Ref 2450.corr.RVBC250827

Barn at Lower Reaps Farm, Whinney Lane, Mellor, BB2 7EL

Application references 3/2025/0507 and 0508

project	project number
lower reaps farm - barn	24.50
name	
proposed - site and landscaping plan	
scale	status
1 to 200 @ A1	may 24 planning

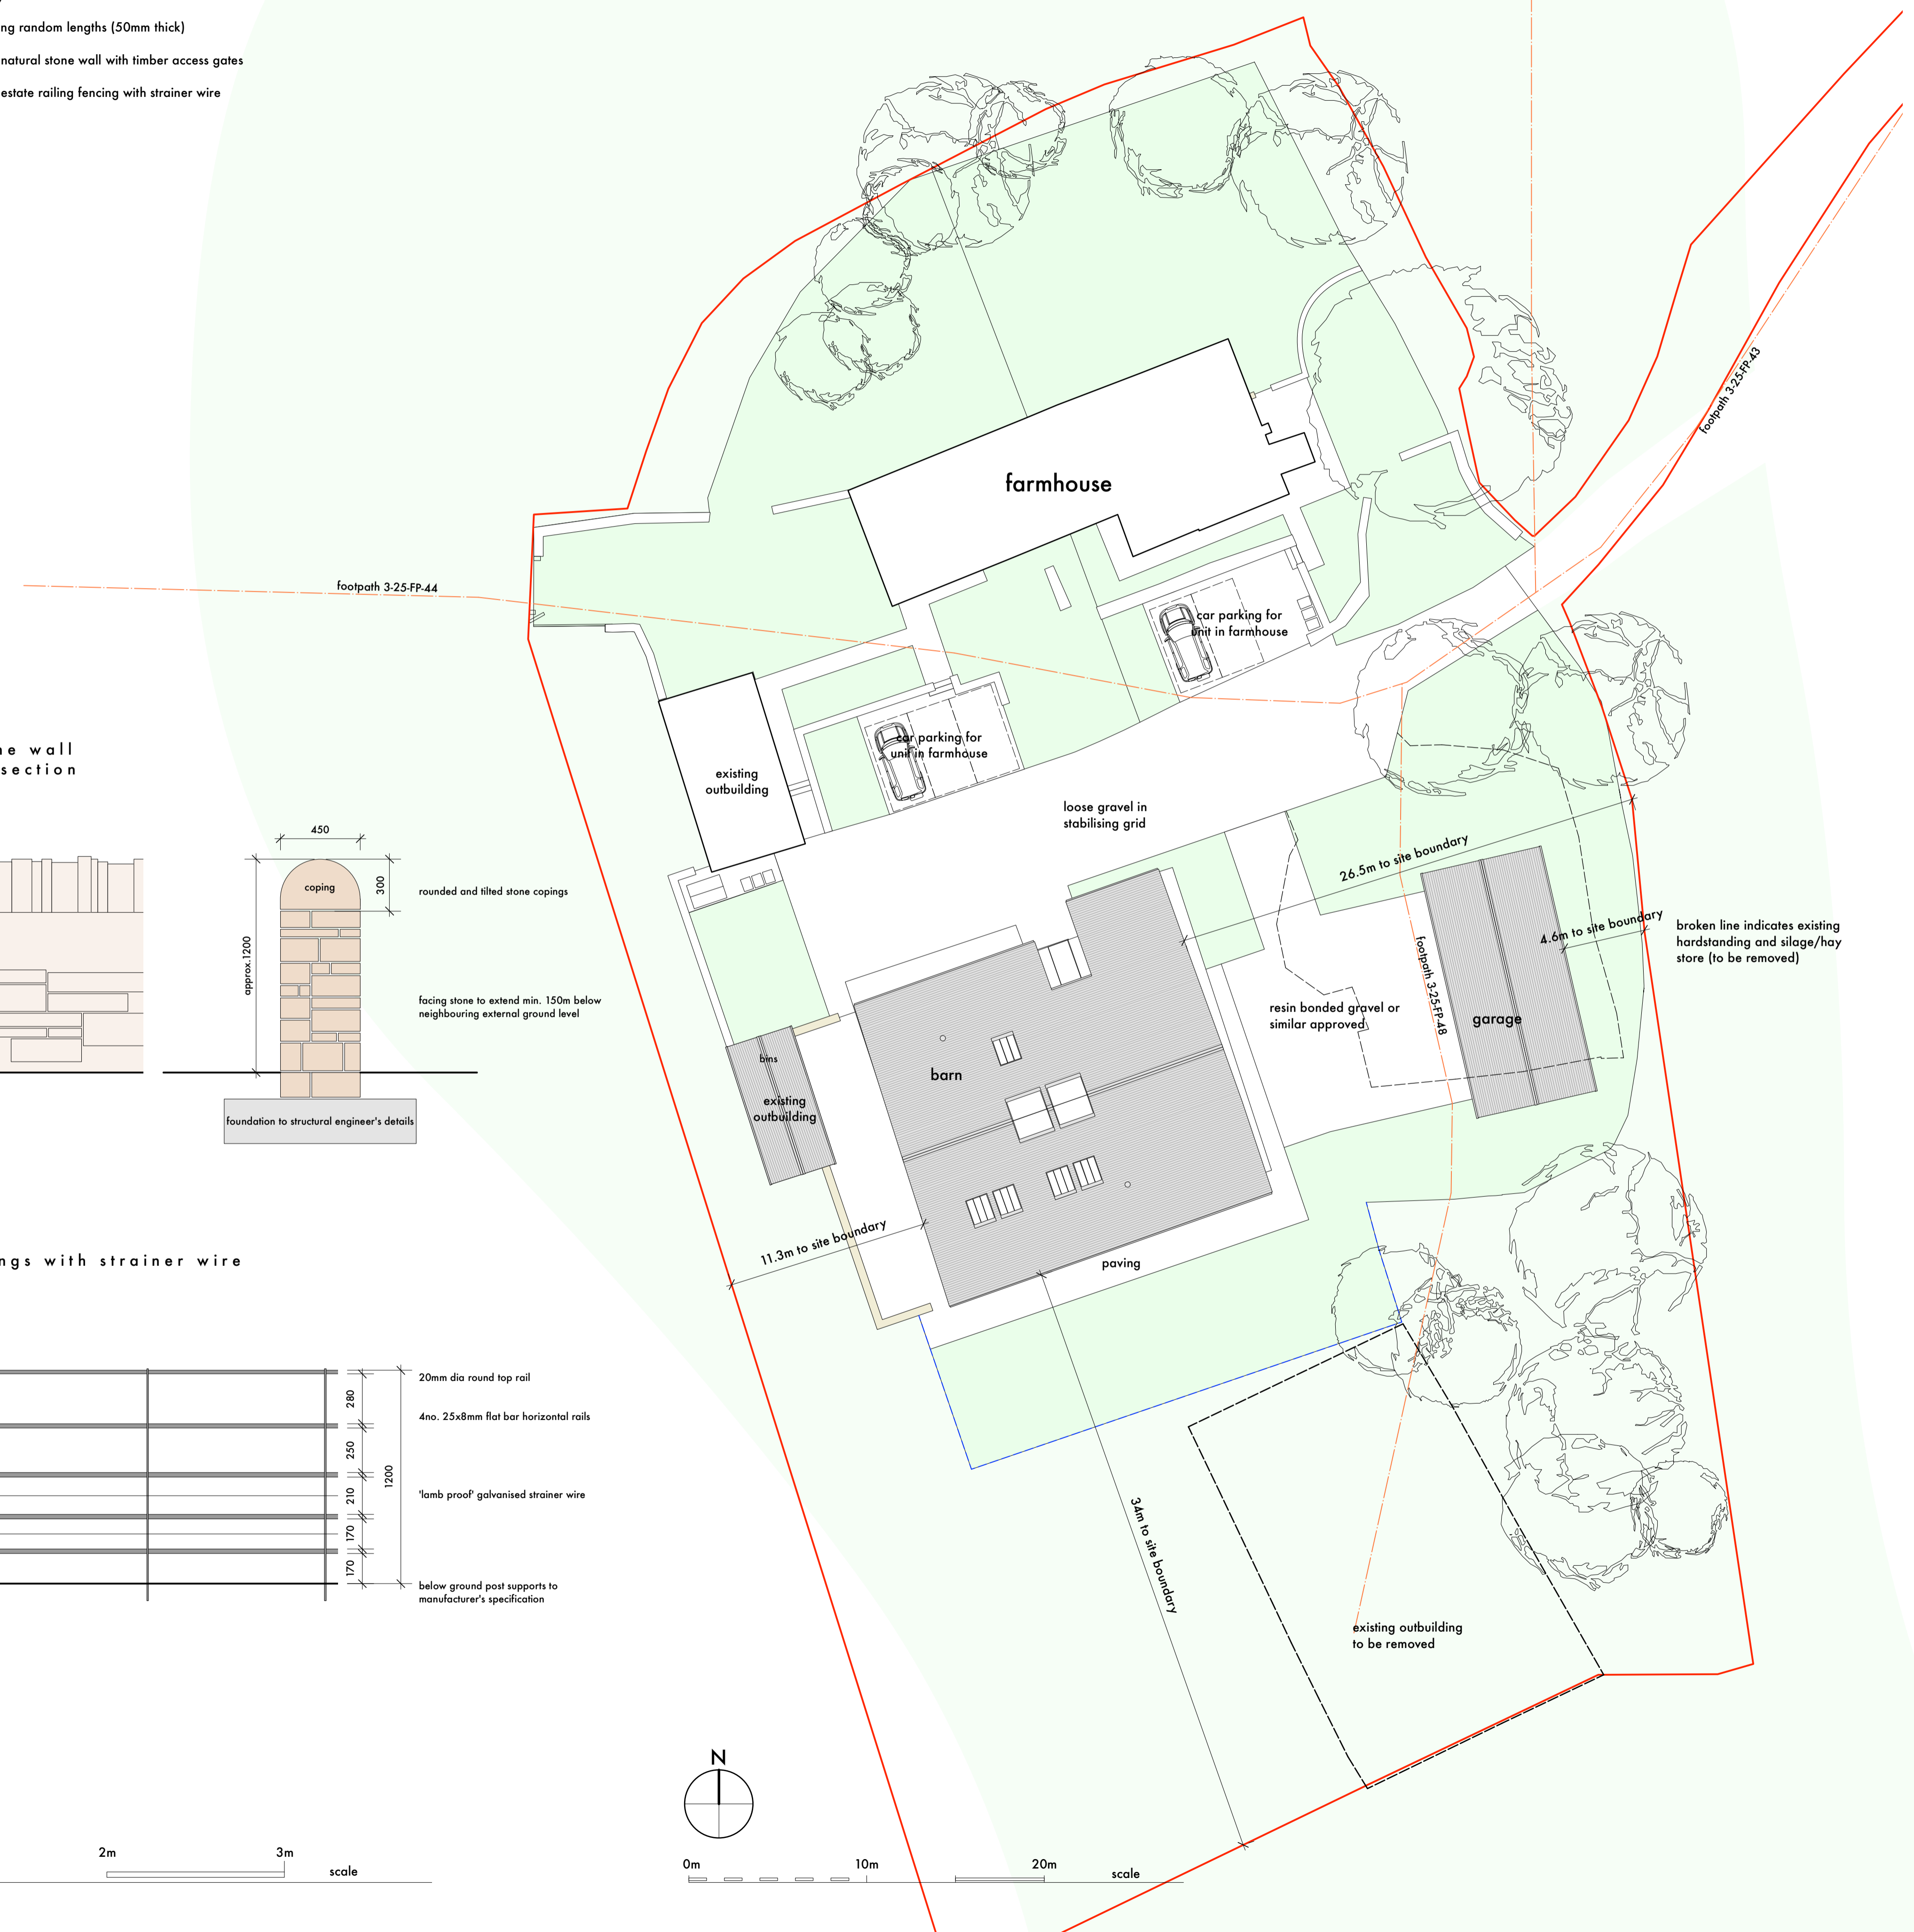
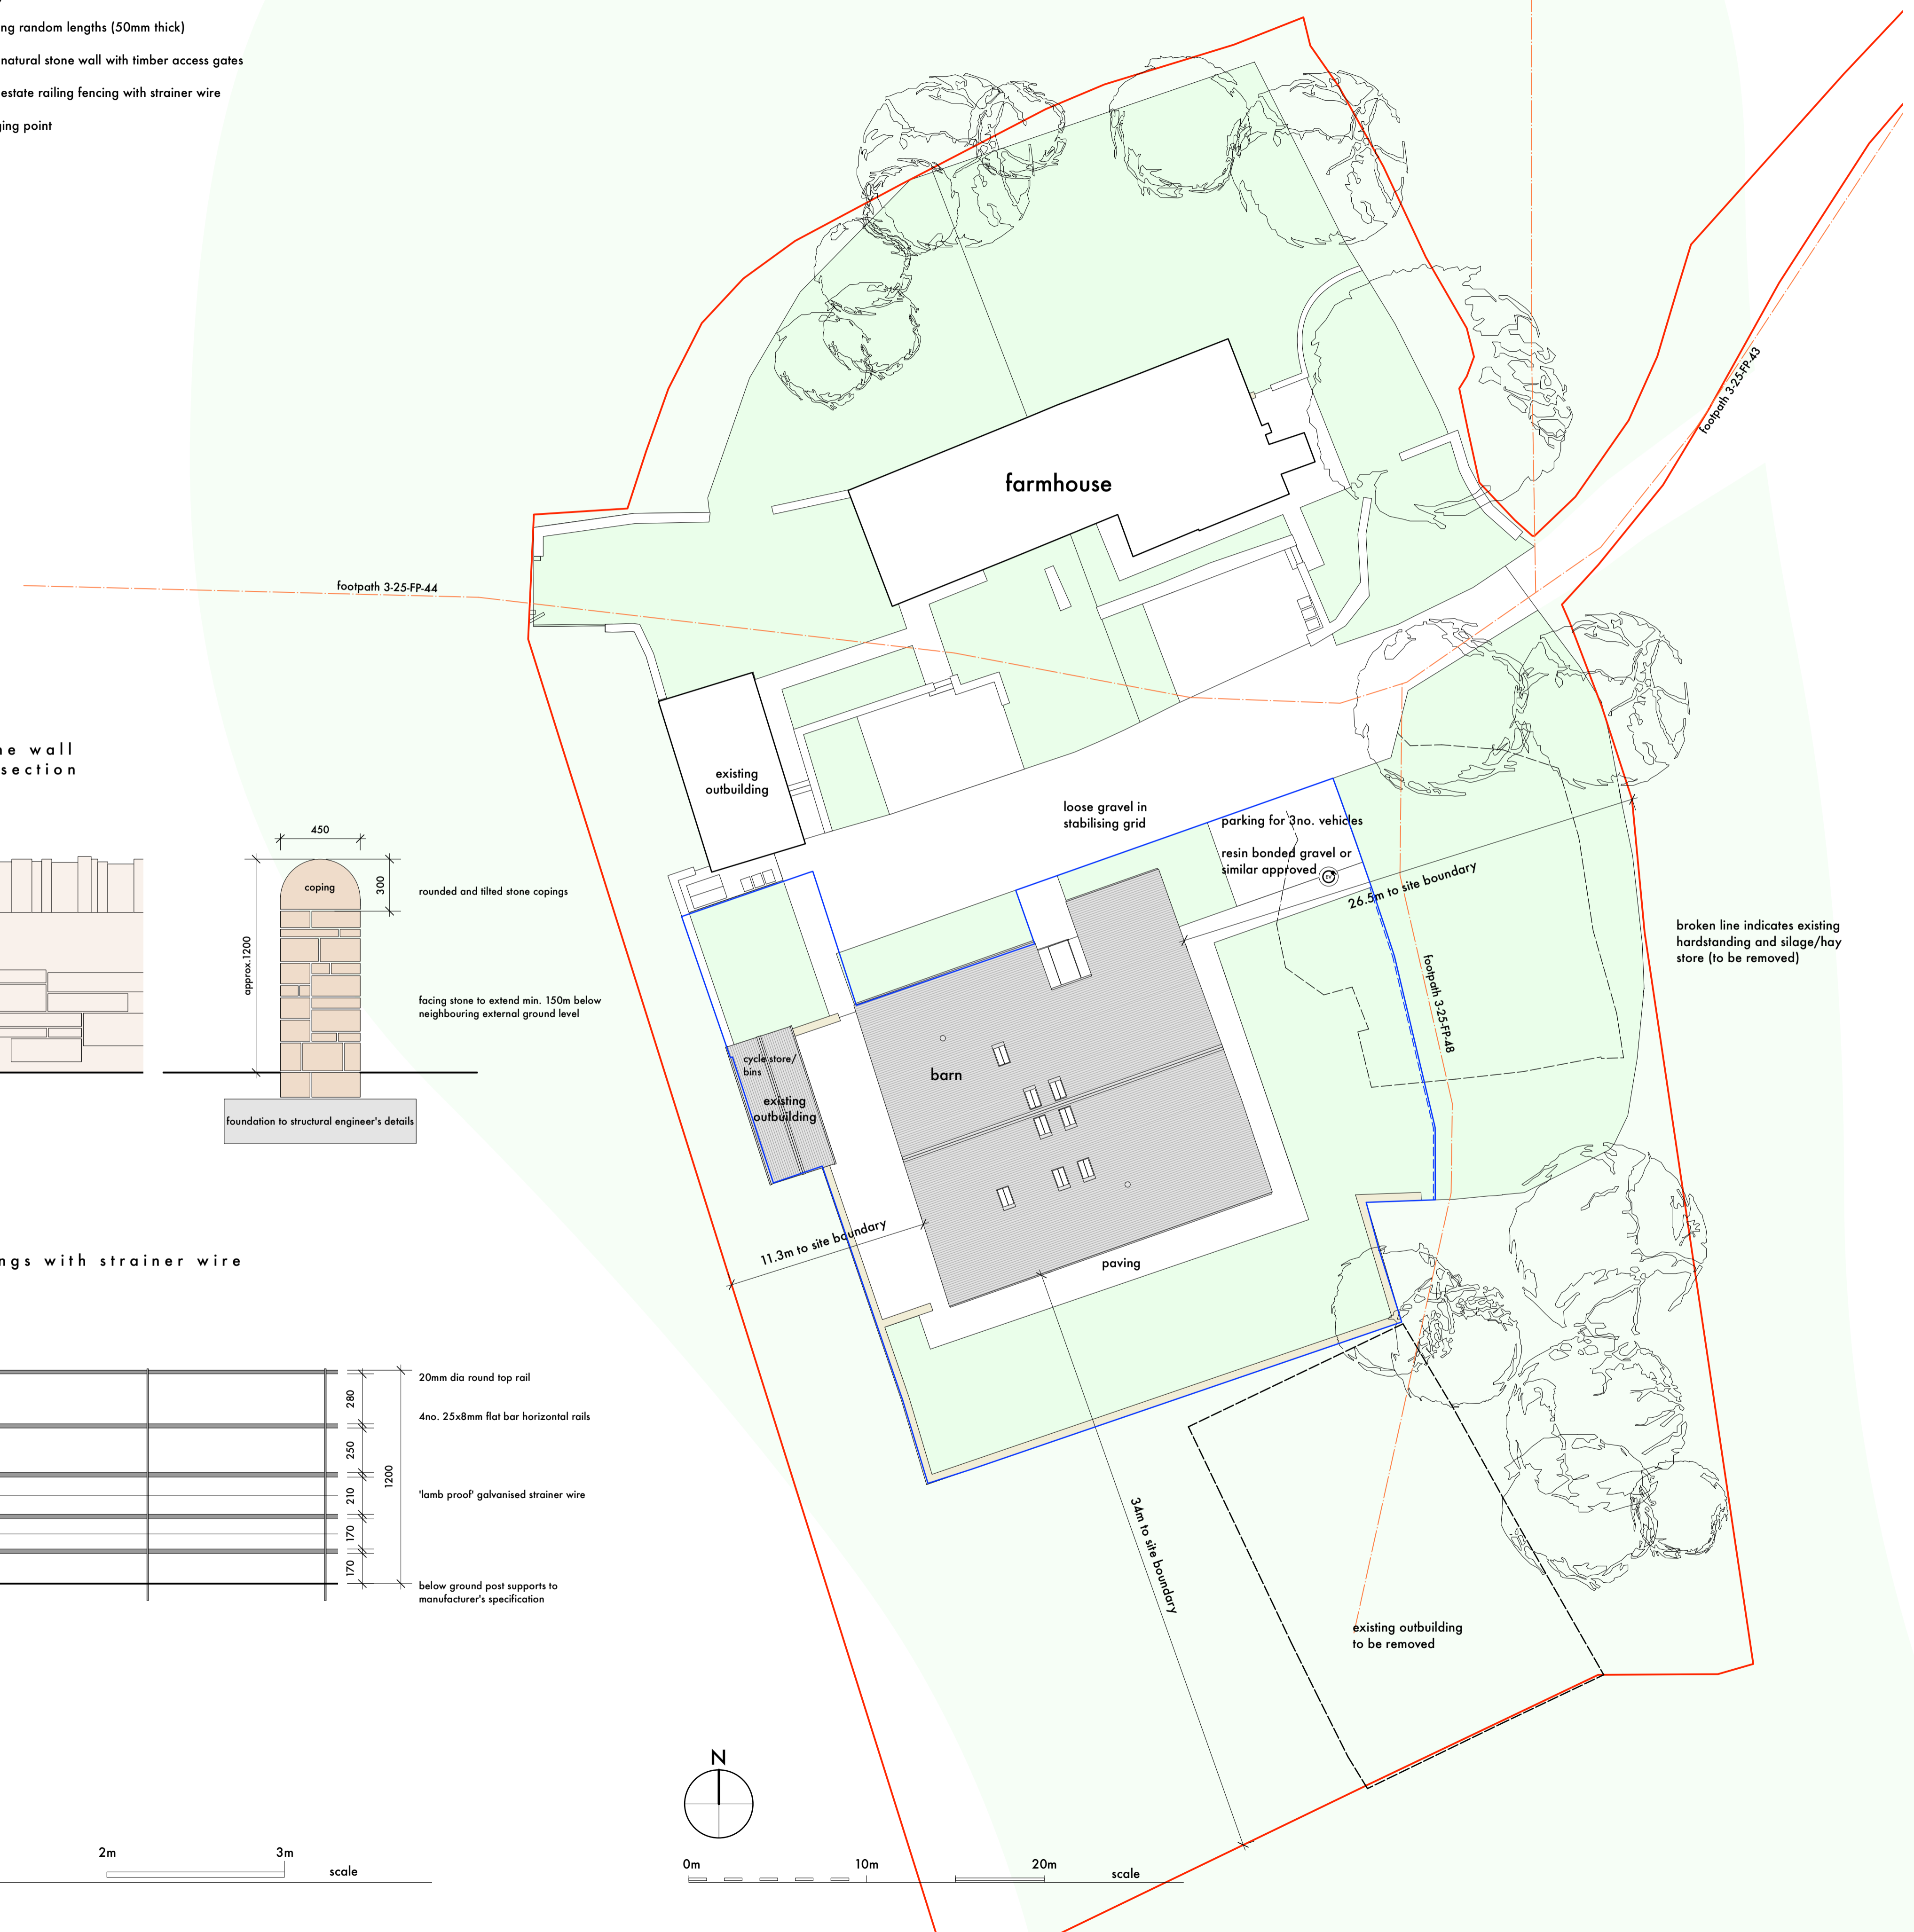
4. *'I am slightly concerned at the scale of the garage and the regularly spaced modern garage openings and the domesticating effect this will have on the barn, and the impact on the listed farmhouse, due to its scale. If the amount of openings and scale could be reduced this would reduce the harm'.*

6. *'The hardstanding also seems to occupy a fairly large area. If there is potential for this to be reduced along with the garaging, this would help reduce impacts'.*

Following these comments (and the comments in your email), the design of the garage has been reviewed and revised. The size of the block has been reduced and the door openings reconsidered with a more agricultural character.

The revised proposals address this concern, showing reduced areas of hardstanding and a smaller garage block.

north elevation

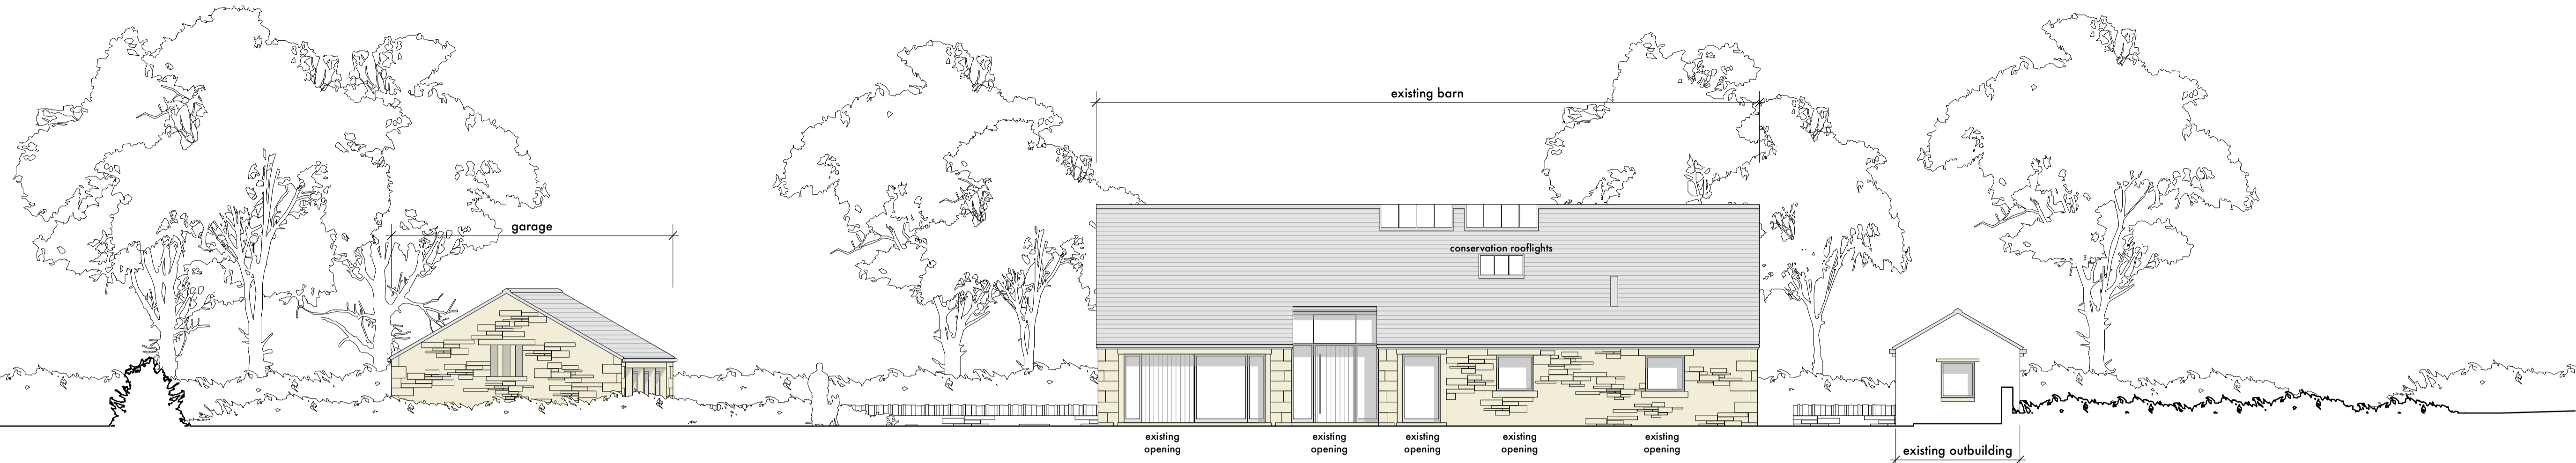
2. *'The proposed doorway in the north elevation would read better as a more simple vertical plank design with small handle to retain its agricultural character'.*

It is noted that the treatment of the north elevation is practically identical to the previously approved scheme (the current scheme actually has less glazing). The door openings are already shown with a 'vertical plank design' as suggested.

**north elevation**

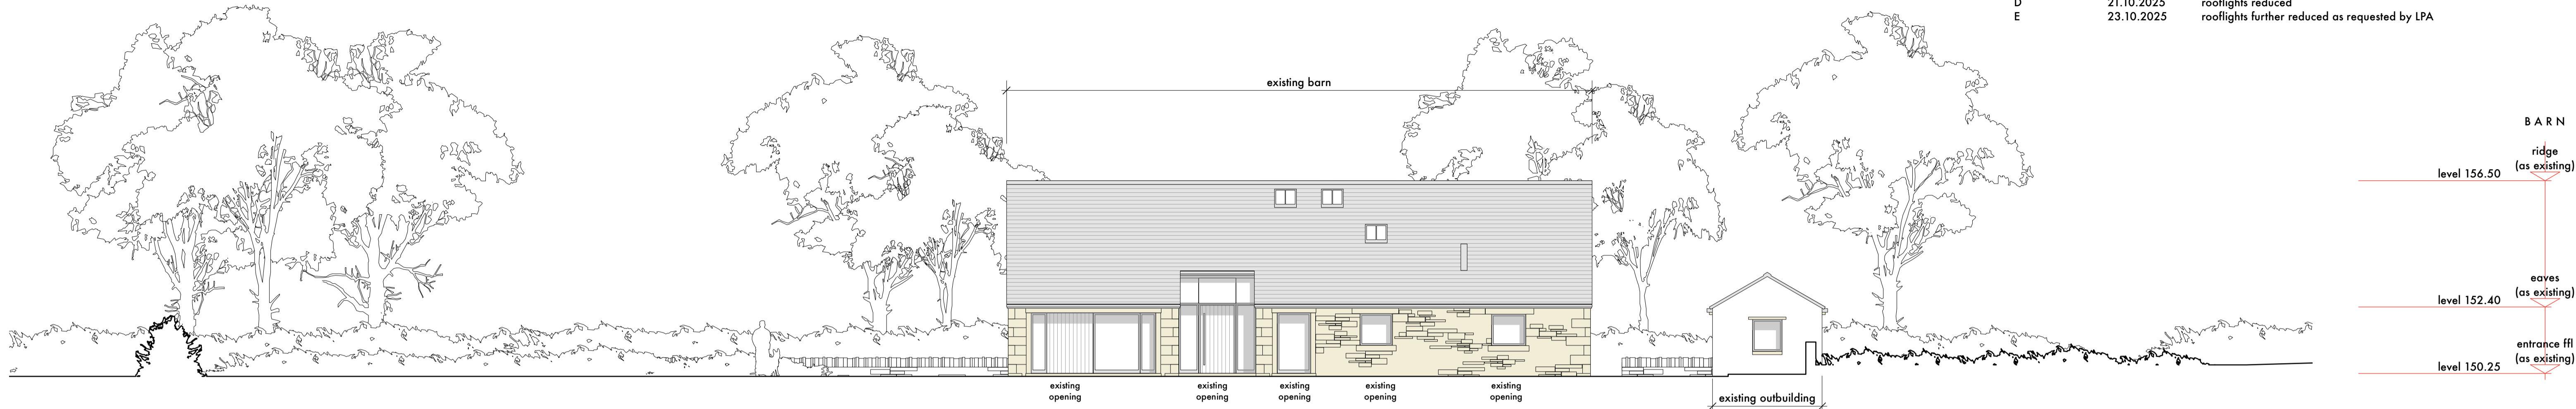
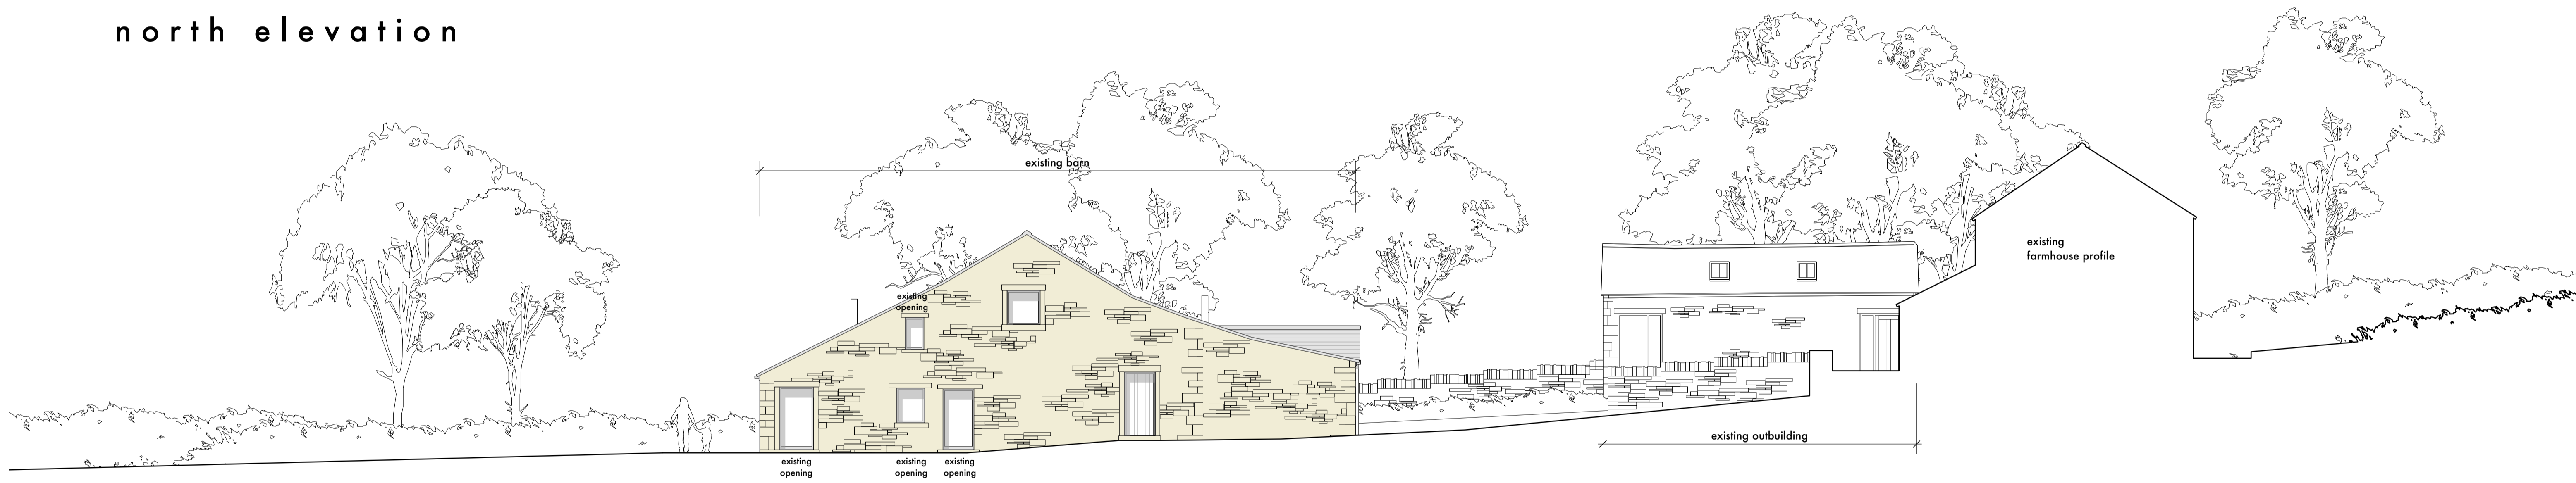
3. *'The amount of rooflights should be reduced if possible, to avoid an overly cluttered effect. Given the roof is corrugated sheeting, larger rooflights may read better than several smaller ones'.*

The existing roof covering is a 'Heath Robinson' collection of slates, stone flags, corrugated sheet and insitu concrete - not solely corrugated sheet as suggested in Northern Powerhouse's comments. The use of slates and conservation rooflights follows the previous approved scheme. Larger rooflights could be substituted for the conservation type rooflights if the planning officer considered this to be more appropriate.
